20 August 2015

Our Ref: 2015/241433

Your Ref: SSI-6622

Submission on the Stage 2 EIS for the Northern Beaches Hospital Road Connectivity & Enhancement Works (SSI-6622)

Modelled locations of the Stage 2 Project (DRAINS and MUSIC) Fig. 16-3

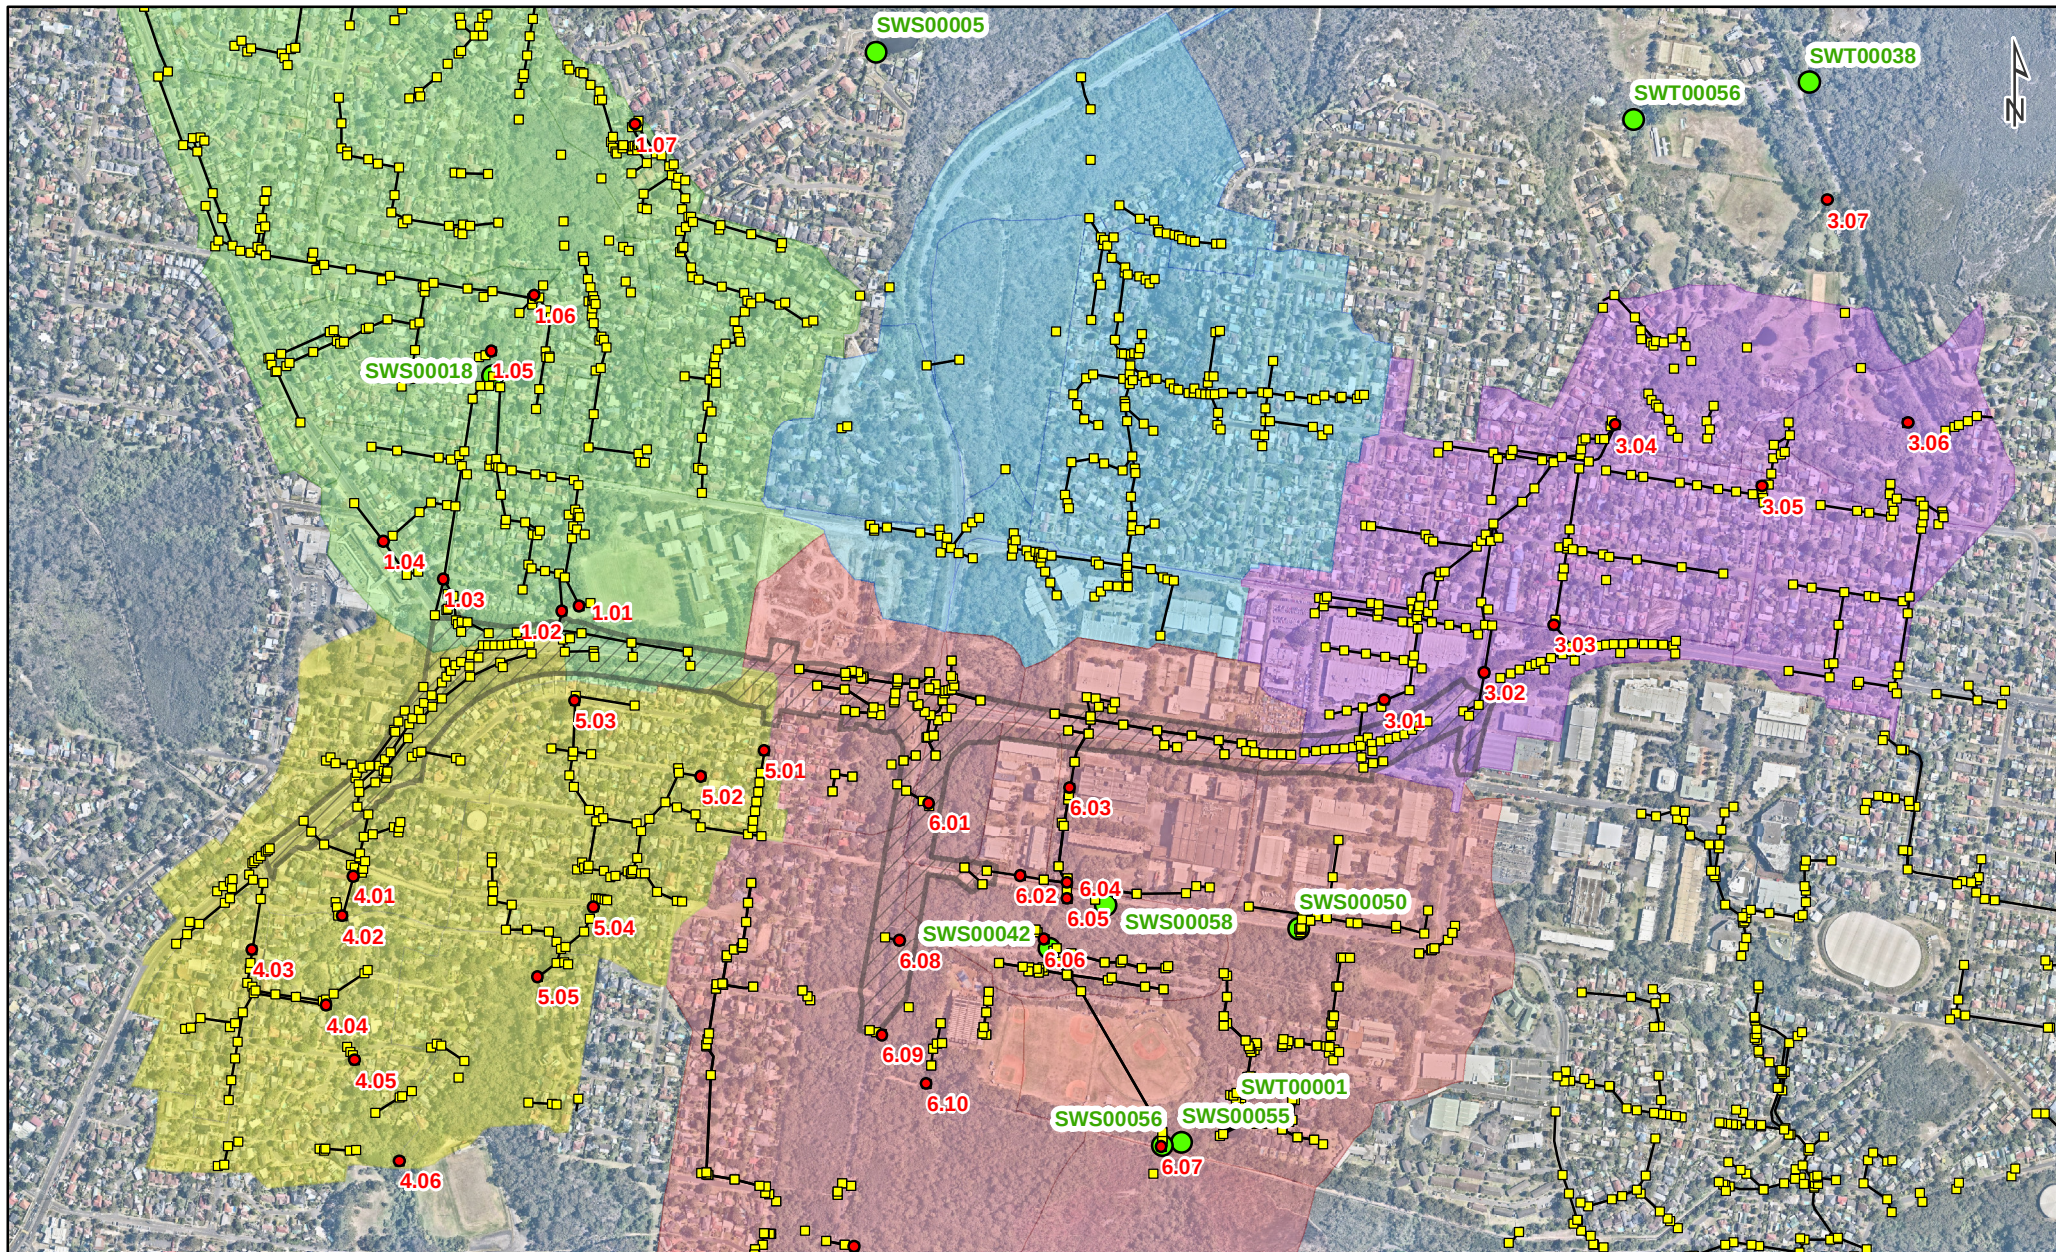
However the EIS notes a 13% simulated increase in nitrogen at 6.01 and up-gradient to 6.06 to Curl Curl Creek (pg.348, Chpt. 16, Vol. 1 & Appendix L – Surface Water Assessment). Assessment must be made as to whether to this falls outside of the adopted water quality objectives of TN - 0.250, Nox - 0.030 and NH4+ - 0.010. In addition, there has not been adequate consideration of groundwater inputs.
